Reference: 190509.01FC

### LETTER OF ADVICE OF PROPOSED RESOURCE RECOVERY FACILITY AT 7 MONTORE ROAD, MINTO

Reference is made to your request to provide Letter of Advice for the Proposed Resource Recovery Facility at 7 Montore Road, Minto (Concept Site layout in **Annexure A**). This letter addresses comments from the Department of Planning in reference to *M<sup>C</sup>Laren Traffic Engineering's (MTE) Traffic and Parking Impact Assessment (TPIA)* dated 5<sup>th</sup> February 2019 (ref 18259.01FB). The Department comments are quoted below followed by **MTE's** responses.

DRAWING TITLE				
SWEPT PATH ANALYSIS - SHEET 2 TURNING MANOEUVRE ON SITE				
PROJECT NO.	PLANSET NO.	RELEASE NO.	DRAWING NO.	REVISION
P1203464	PS02	R15	PS02-DZ02	H

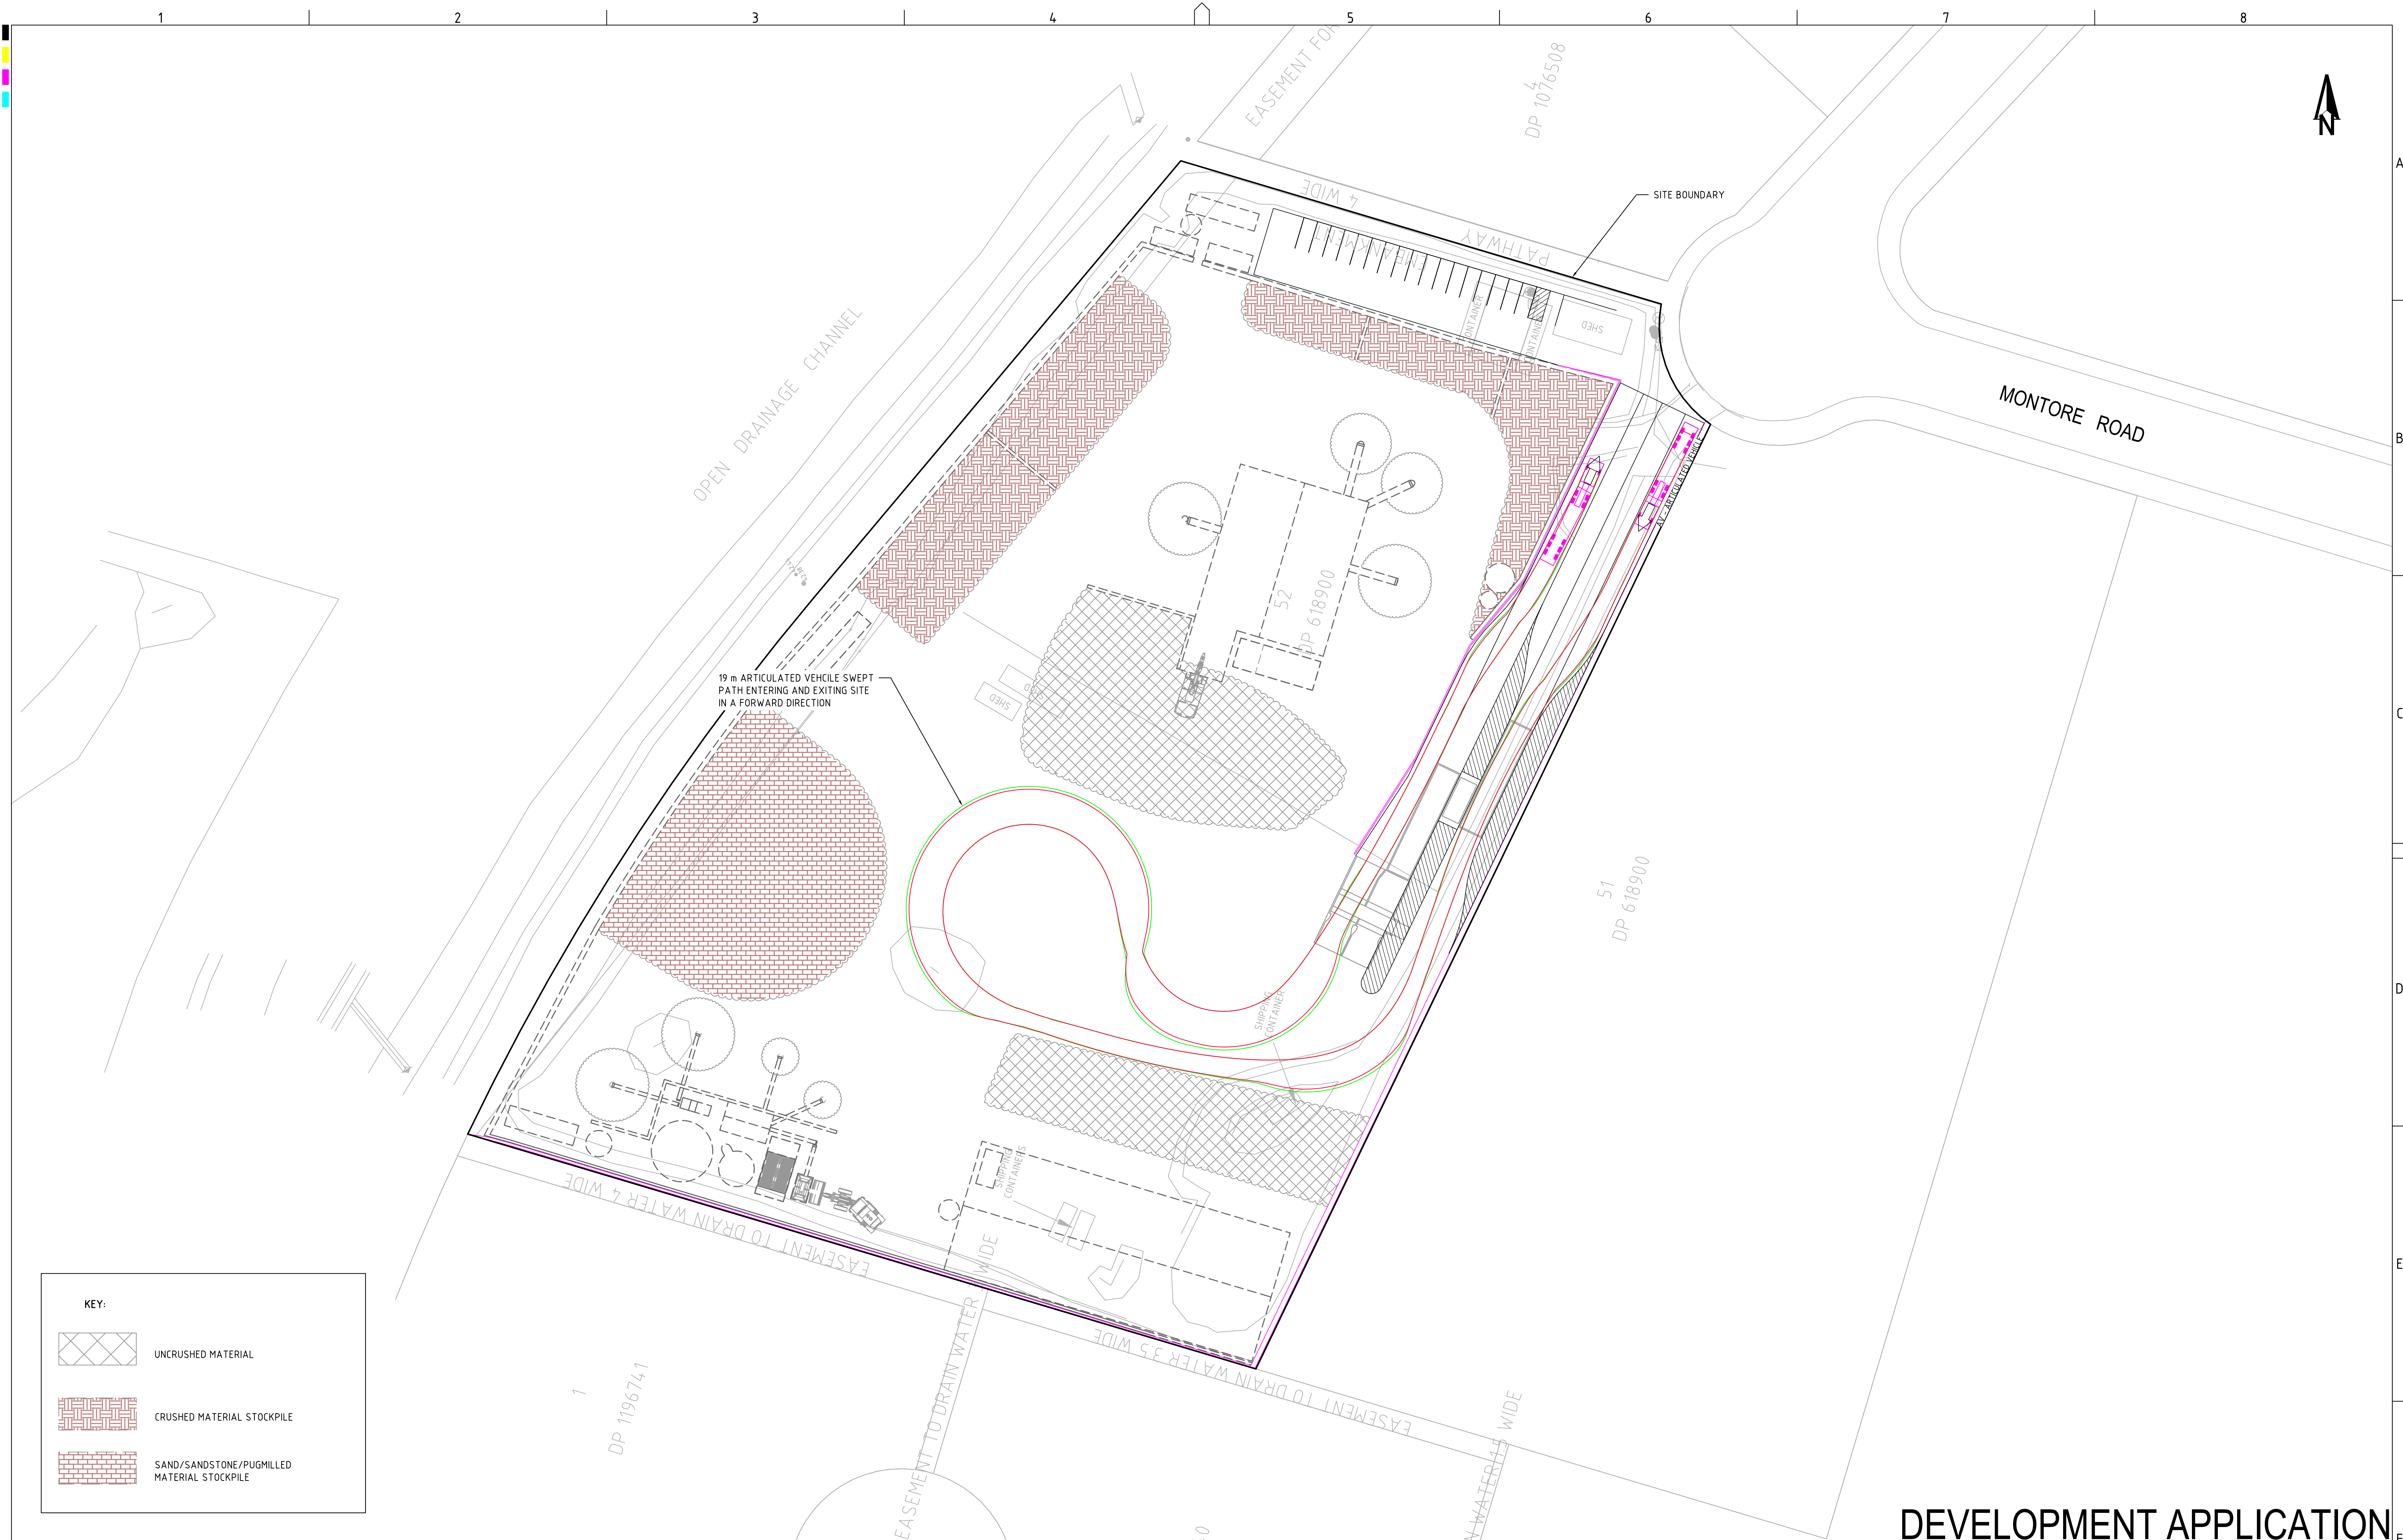
*Section 10.4.3 of the EIS states that each industrial building/unit having a gross floor area more than 1,500m<sup>2</sup> will provide a loading area to allow for heavy rigid vehicles to manoeuvre – please discuss this aspect in the project description and show the loading areas on a plan.*

**MTE Response:** Heavy vehicles up to 19m long articulated vehicles can circulate throughout the site. Loading and unloading operations will occur in multiple locations which can all be accessed by a 19m long articulated vehicle. It is important to note that neither the loading and unloading areas block heavy vehicle circulation around the site, allowing unrestricted vehicle flows within the site. Swept paths of an articulated vehicle circulating the site while loading and unloading activities (shown in indicative locations) are occurring is provided in **Annexure C**. Additionally, the figures provided in **Annexure C** are included in the modified *TPIA*.

DRAWING TITLE				
SWEEP PATH ANALYSIS - SHEET 3 ENTRANCE AND EXIT MANOEUVRES				
PROJECT NO.	PLANSET NO.	RELEASE NO.	DRAWING NO.	REVISION
P1203464	PS02	R15	PS02-DZ03	E

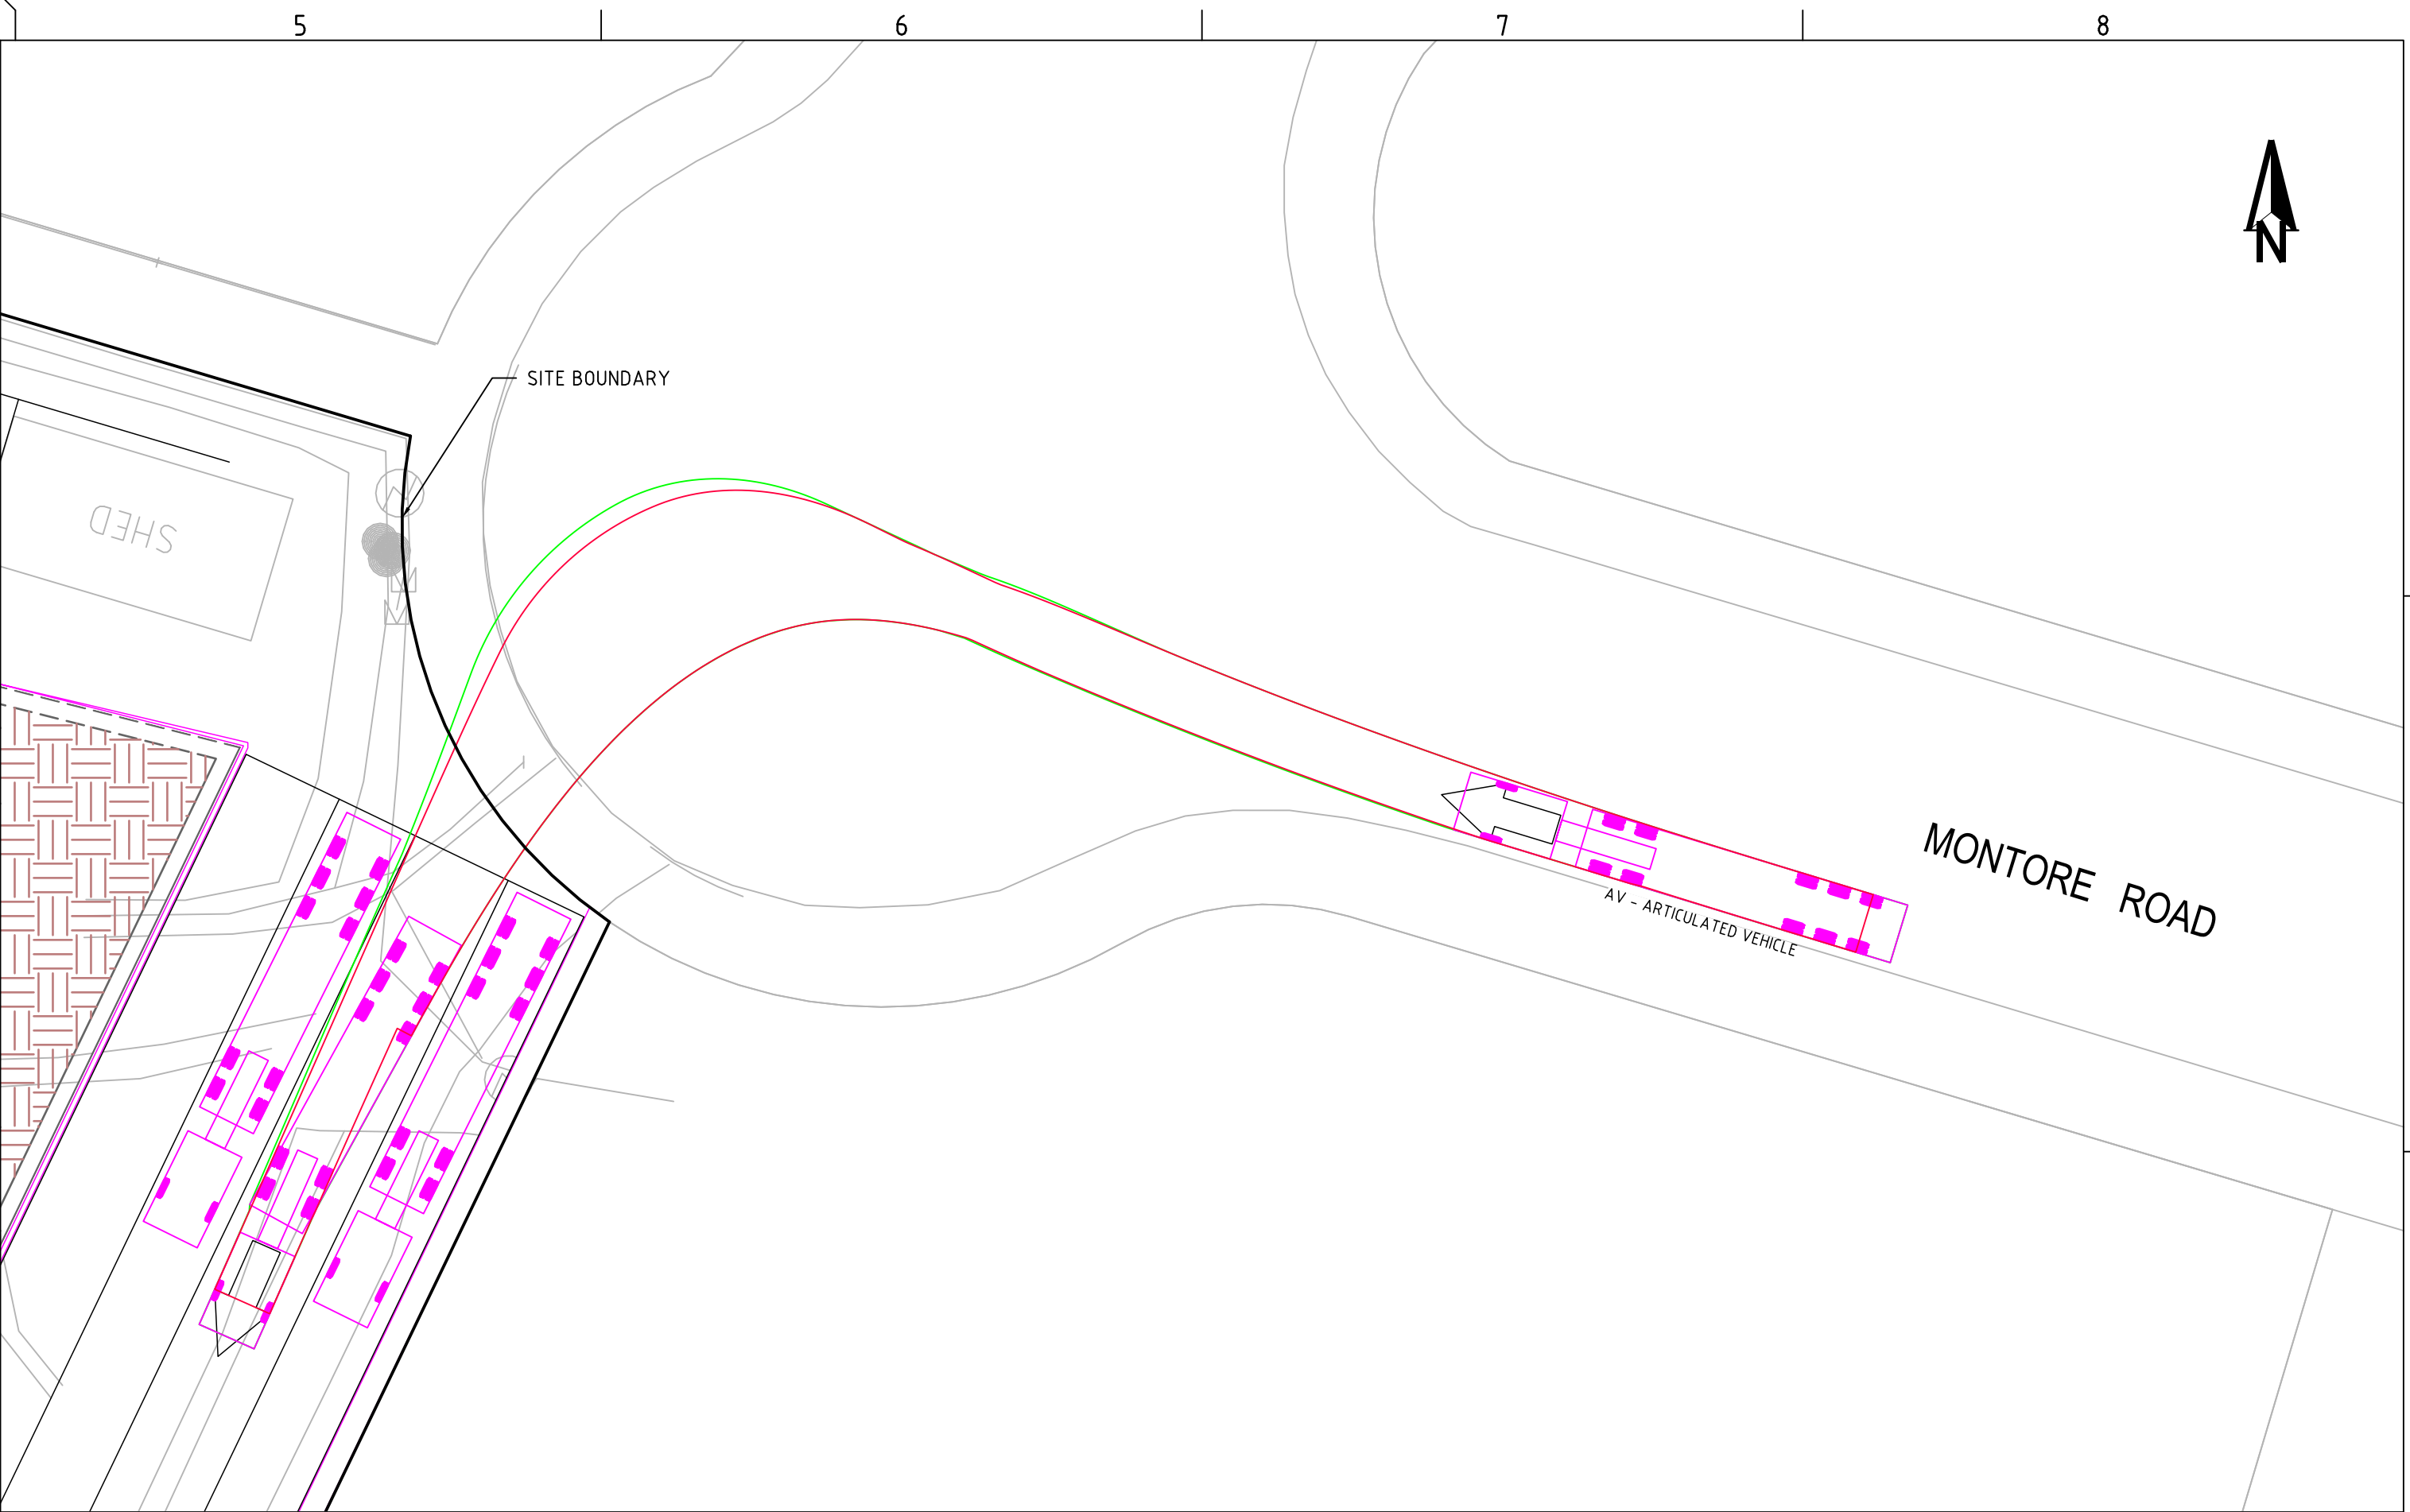
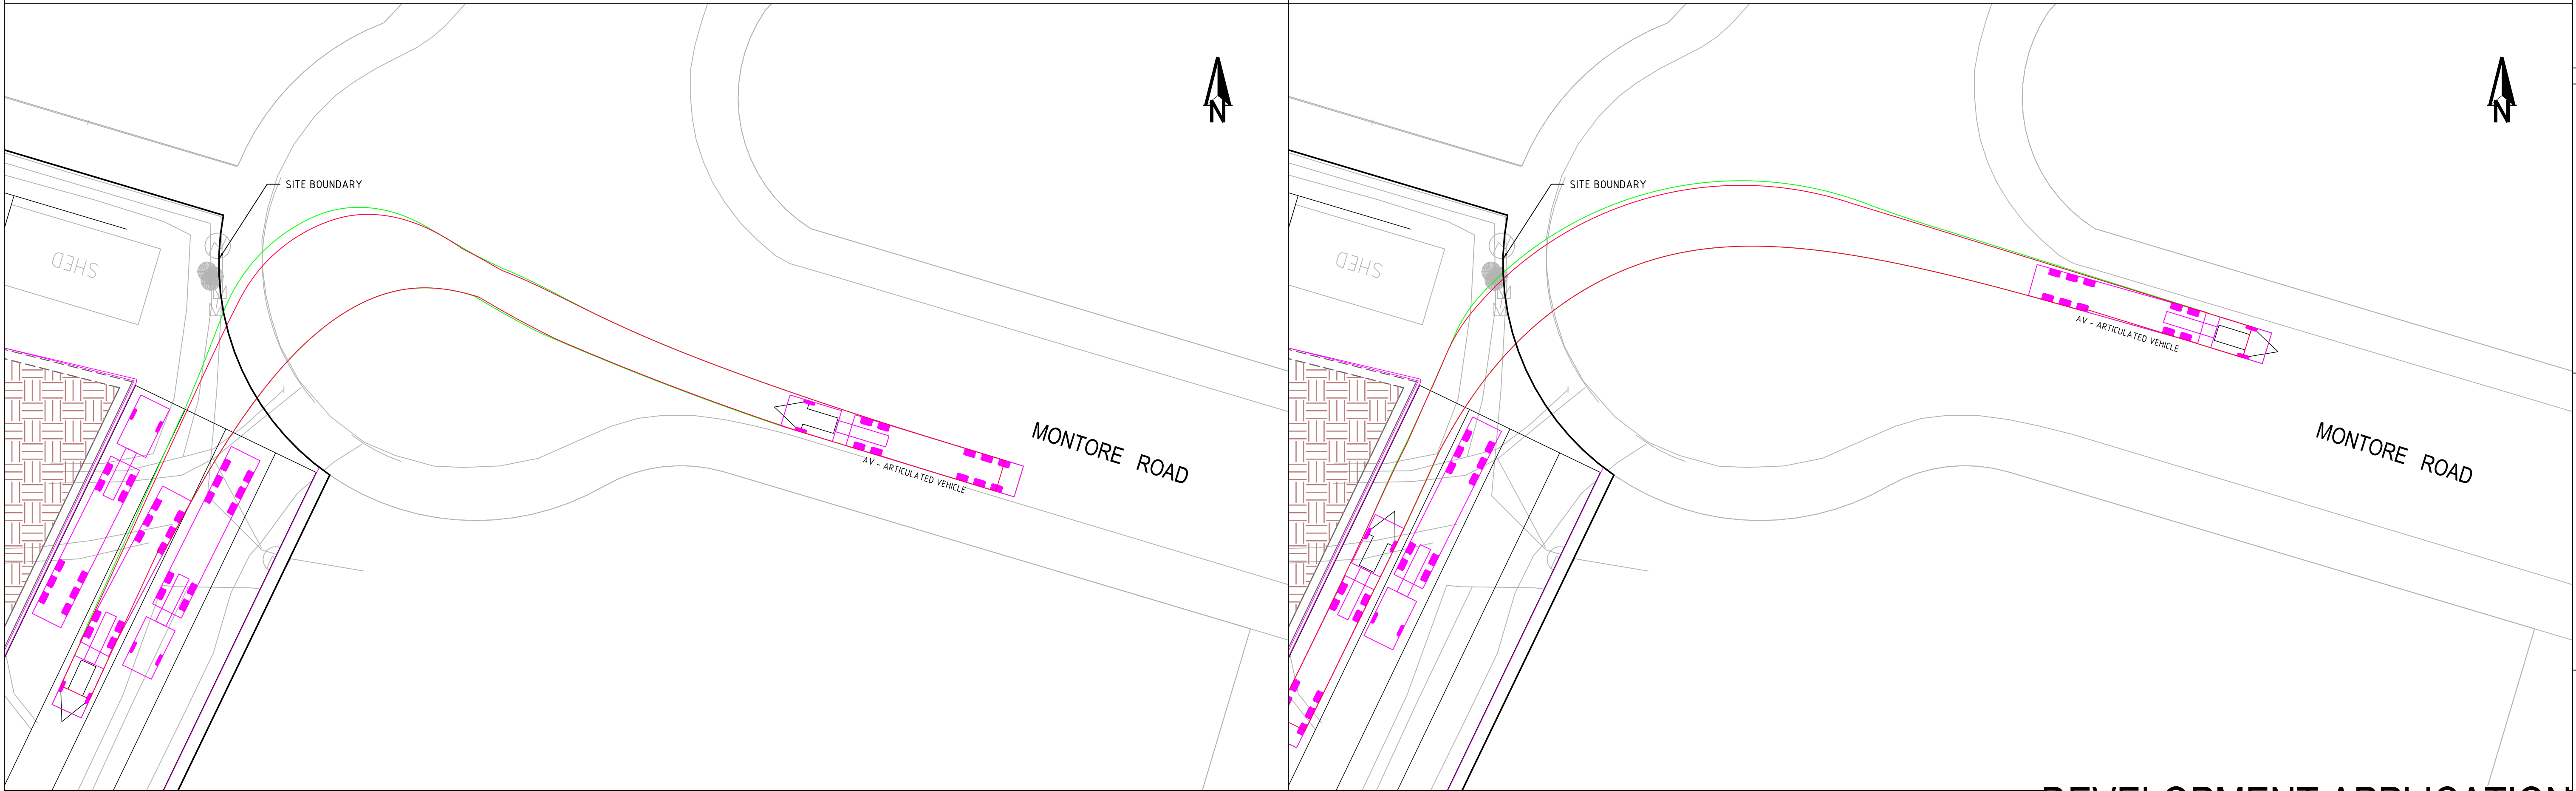
*Describe the site access, will it be upgraded?*

**MTE Response:** The site access is shown in the plans in **Annexure A**. The proposal requires a significantly wider layback than what is provided on the existing site. The singular layback will provide access and egress to both the weighbridge for AV's and the car park for passenger vehicles. The existing and proposed laybacks are compared in **Figure 1** and **Figure 2** below. Additionally, the original TPIA, dated 5<sup>th</sup> February 2019, has been updated to include these figures.
